**Nottinghamshire County Council**  
**One Earth Solar Farm EN010159**  
**Landscape and Visual Impact Summary from Issue Specific Hearing 2**

1. This submission has been prepared by the County Council's landscape advisors to confirm the position of the County Council following Issue Specific Hearing 2 (3 September 2025) and in response to the action points from the Examining Authority.

Viewpoint 9a View from Moor Farm on public bridleway (NT/North Clifton/BW10) (Summer)

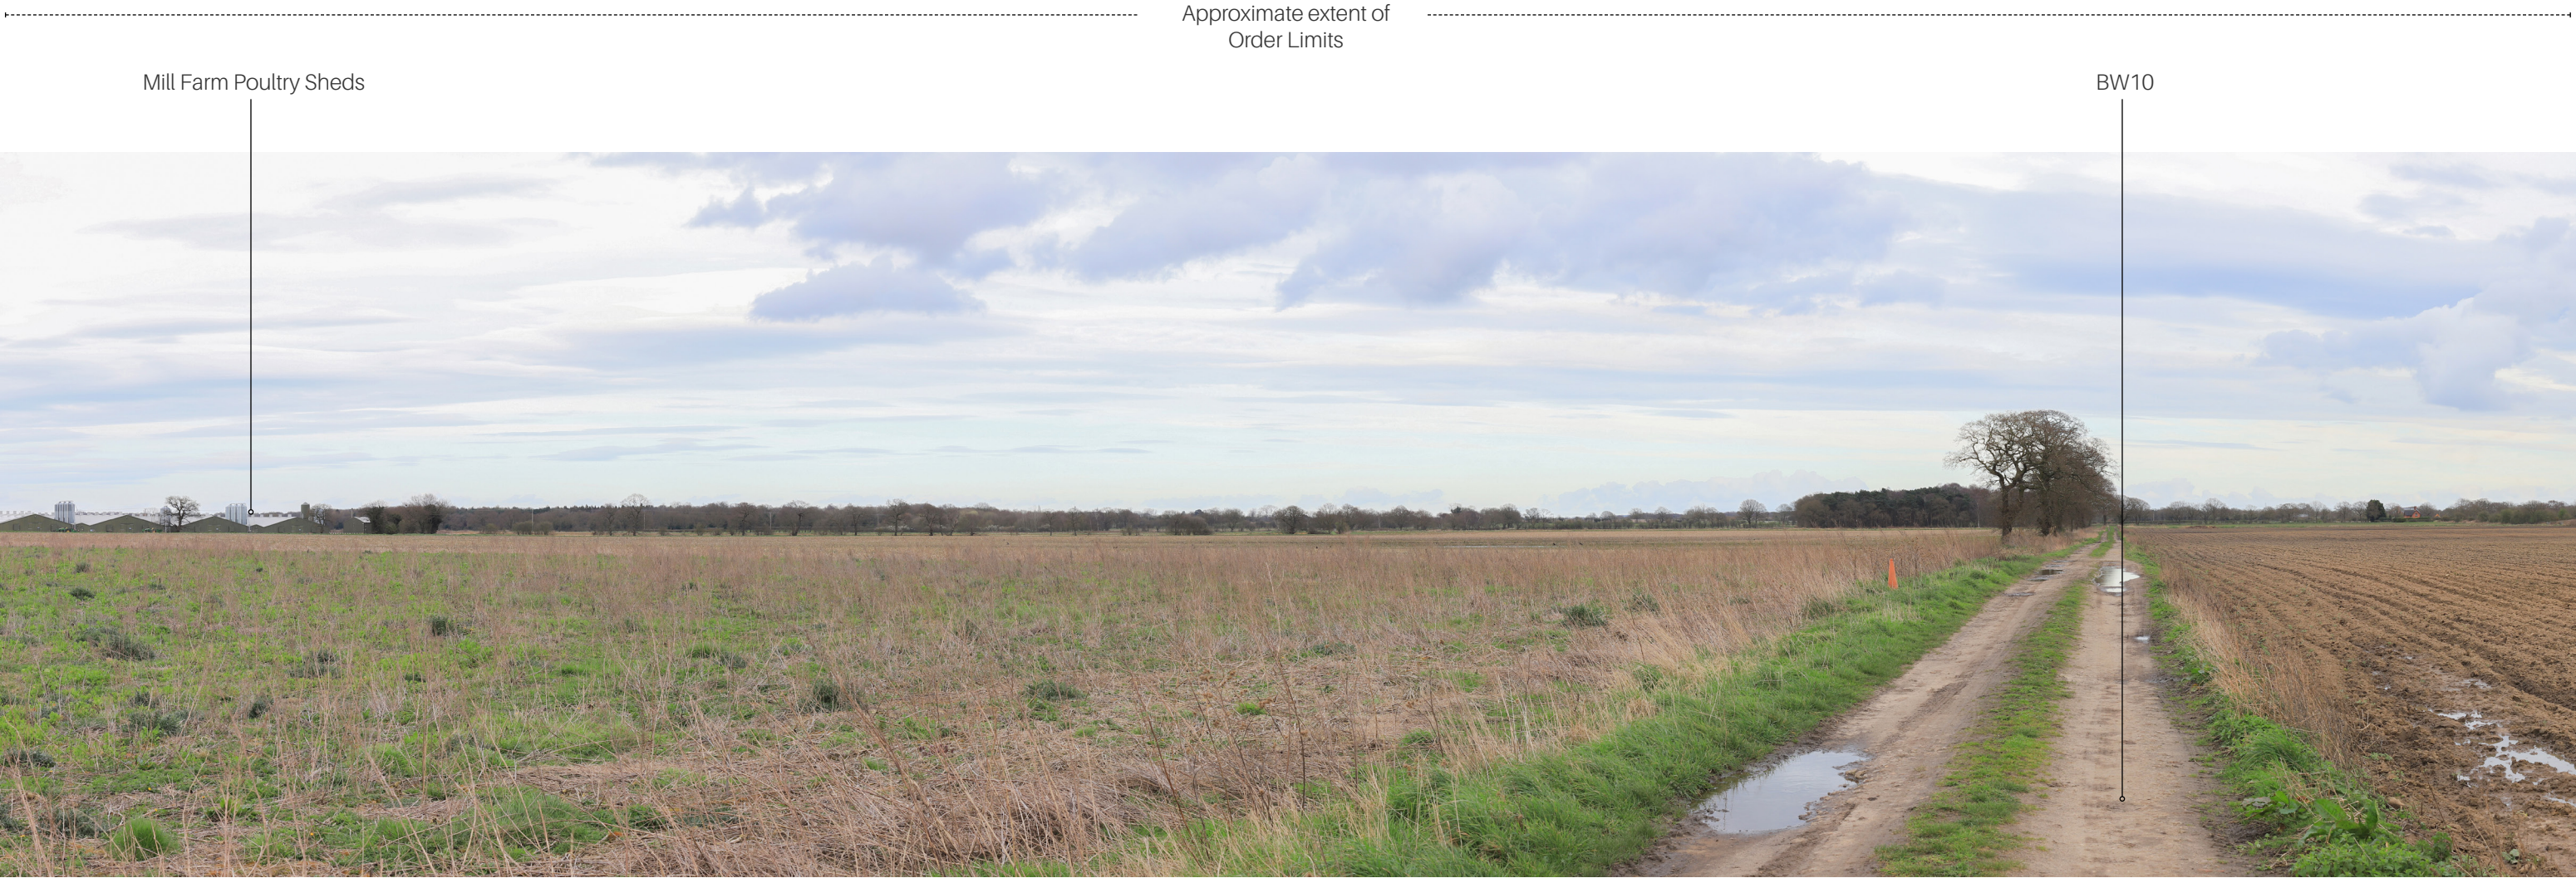
13. As an example, users of public bridleway NT/North Clifton/BW10 will have a varying experience along the route, as well as varying views of the Development. This receptor will have closer range, and likely clearer views of the Development while passing through the south eastern section of the Site, however their visual experience is only captured and described in one static view at Viewpoint 9, which is much further from the built elements than at other locations, and subsequently may have been assessed as having a lesser effect.
